In reply please quote: 21/02748

## **FAIRFIELD CITY COUNCIL RESPONSE - SSD 7664 MODIFICATION 2 AND SSD 10404 MODIFICATION 1**

### **A. COMMENTS SSD 7664 MODIFICATION 2**

### **B. COMMENTS SSD 10404 MODIFICATION 1**

Figure 9 Proposed Elevations (South and West) – SSD-10404-Mod-1

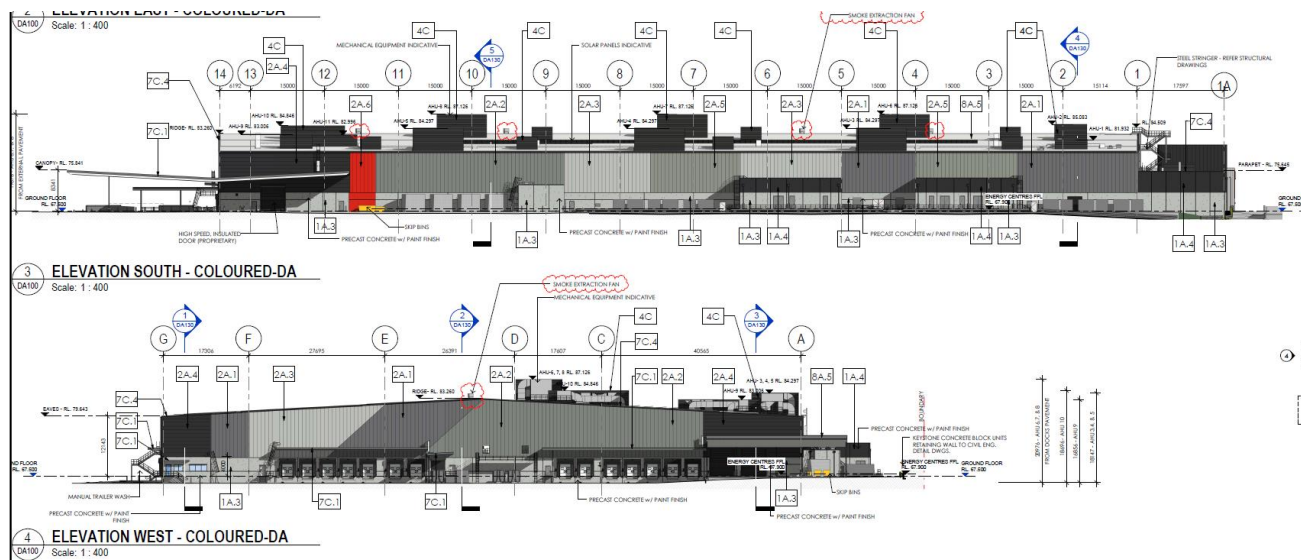
Council officers do not object to the placement of plant and equipment on the roof. It is recommended that rather than modify condition 10a of SSD 7664, the department rely on the Standard LEP Clause 5.6 "*Architectural Roof Features*" of the Fairfield LEP 2013 to approve these structures. The clause permits variations to maximum building height standards where roof features contribute to the overall building design. In this instance, any plant or equipment exceeding the maximum height of buildings would need to be contained in or supported by a roof feature (screening), ensuring that it is fully integrated into the roof design. Council officers note that the plant and equipment is proposed to be adequately screened. The Department could determine the suitability of this aspect of the proposal by including a merit assessment of the proposal against the Provisions of Clause 5.6.

**Canopy heights** –The proposed height of canopies over the fuel bays/tanks shown on the modification plans is unclear and whether sufficient clearance will be available to heavy vehicles utilising these facility. In this regard, prior to construction more detailed information regarding the height of these structures needs to be submitted to Council for approval.
